# HABIT8

### RE: EIS- Adequacy review comments (SSD- 17552047)

Aldington Road Estate, Kemps Creek NSW

LANDSCAPE SECTIONS 01

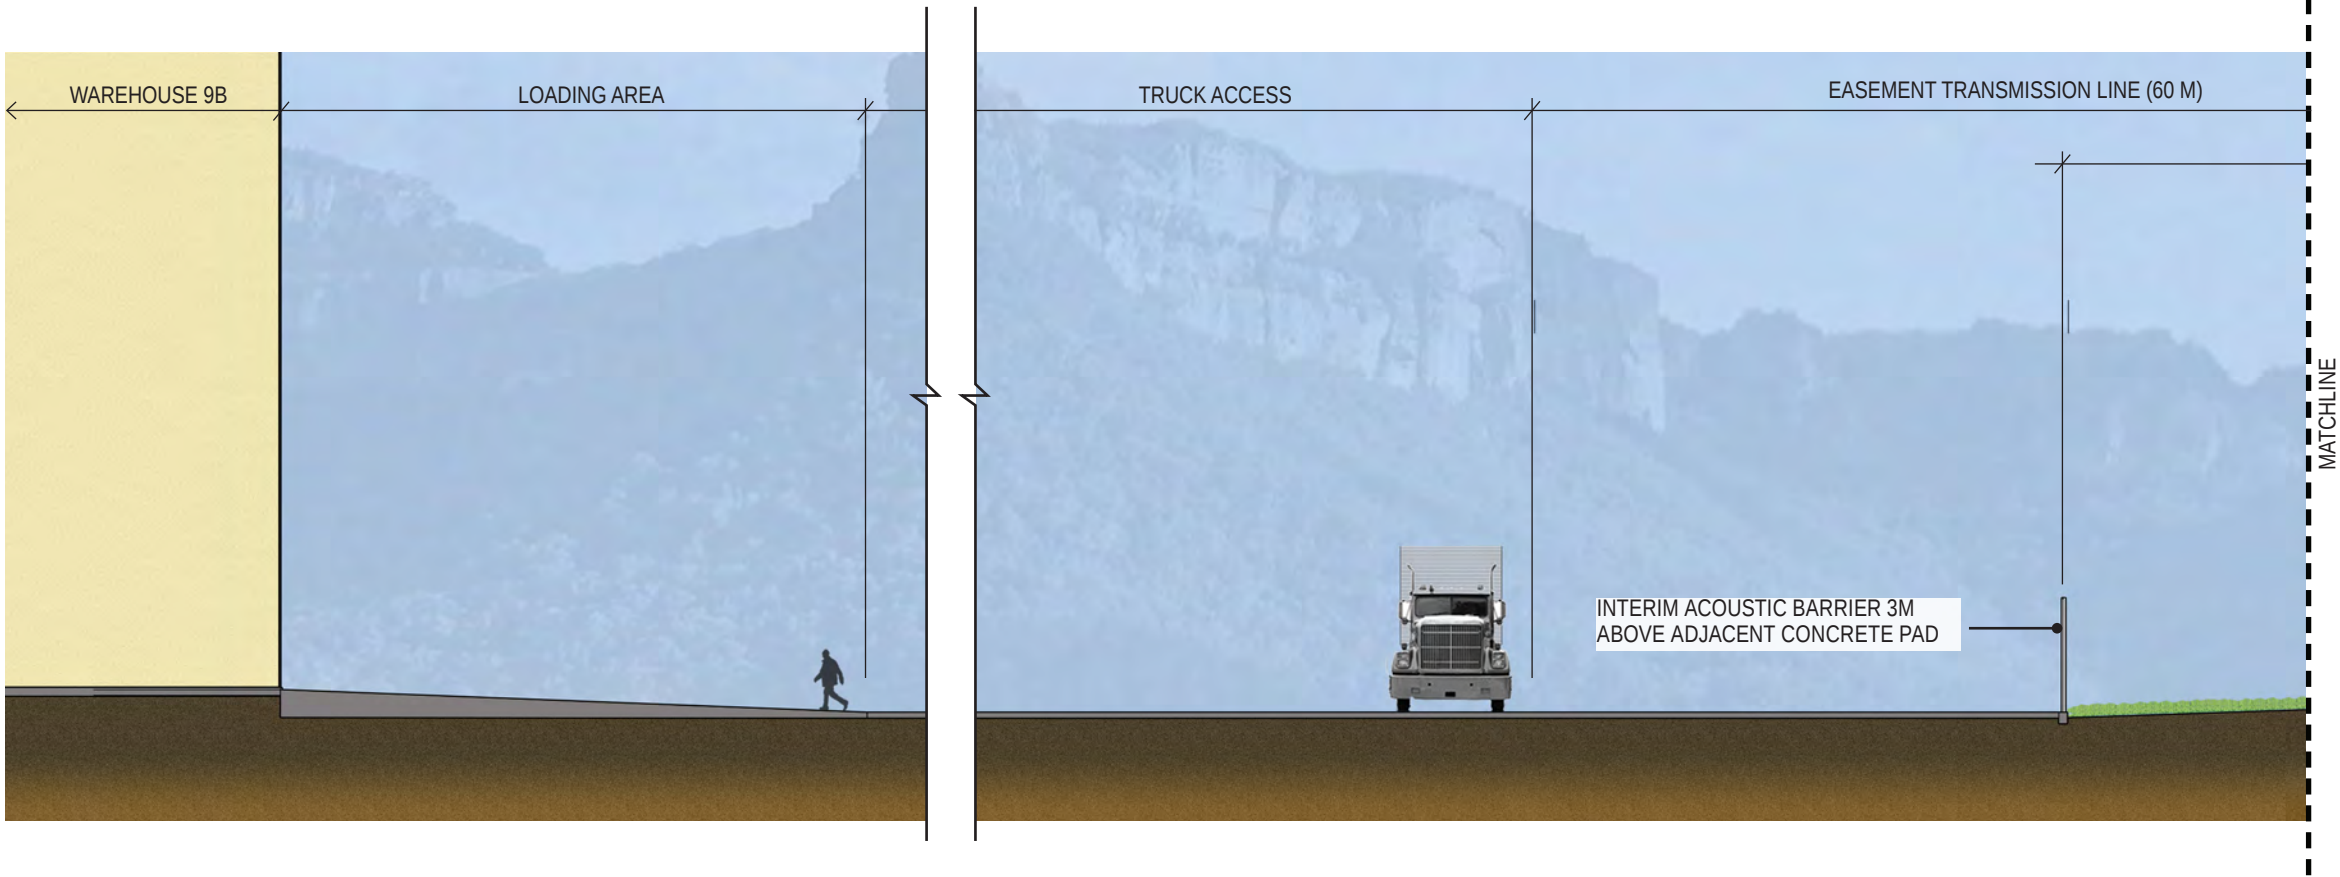
2.0	<i>Provide additional information of the interface treatments which would minimise visual impacts upon adjoining land and visual impacts more broadly.</i>	Habit8 have clarified where significant screening vegetation is implemented to mitigate the visual impact of the project through the amendments to the LVIA 3D views, additional sections and an update to the landscape concept plan.

Figure 5: Typical retaining wall section

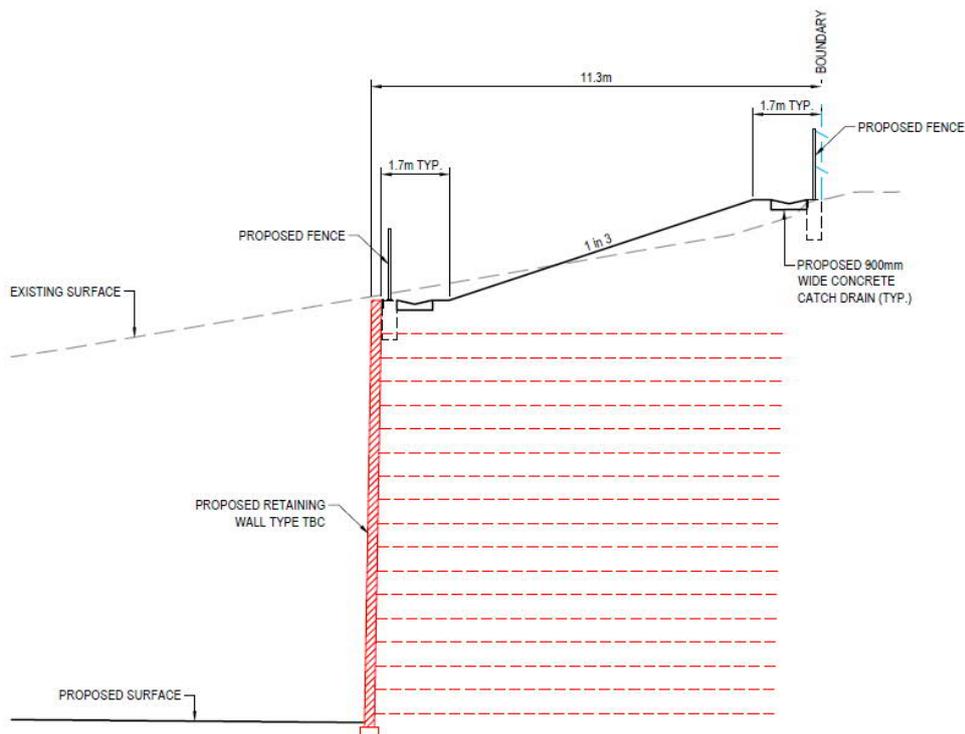
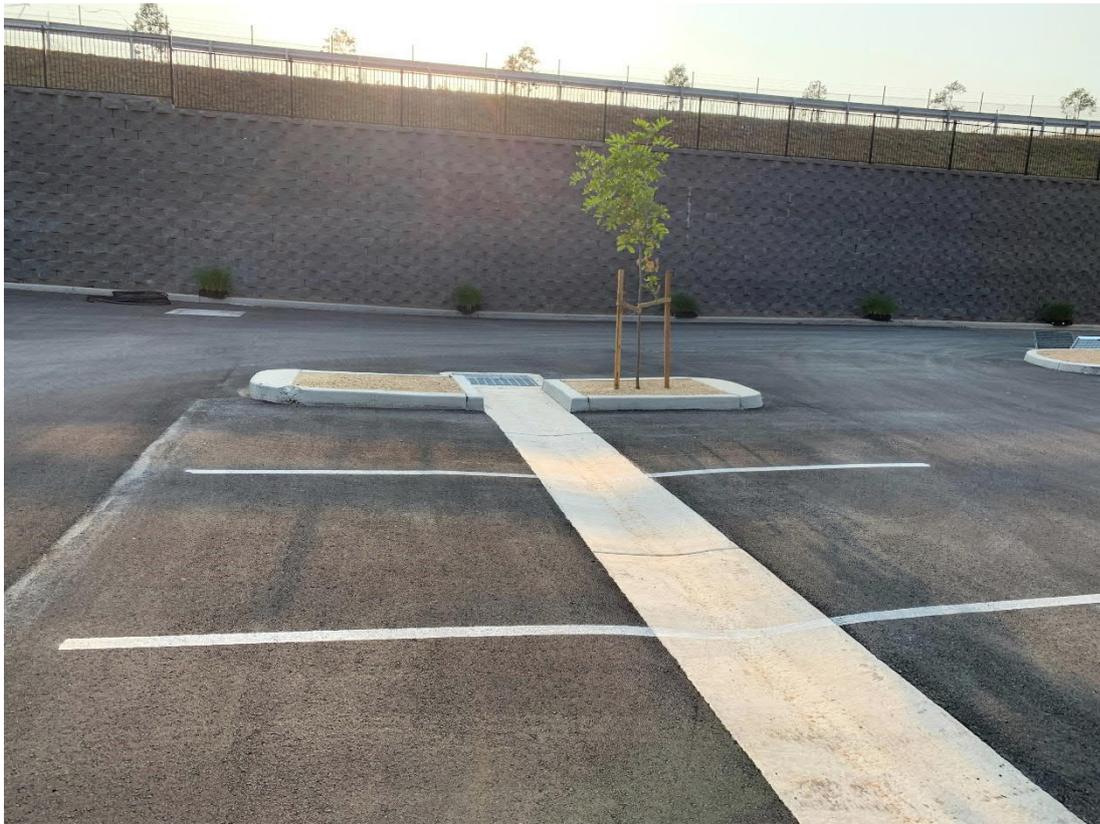
3.0	<i>Provide further details of the construction of the proposed retaining and acoustic walls alongside a justification/need for the proposed height</i>	Please see Civil engineering documentation.
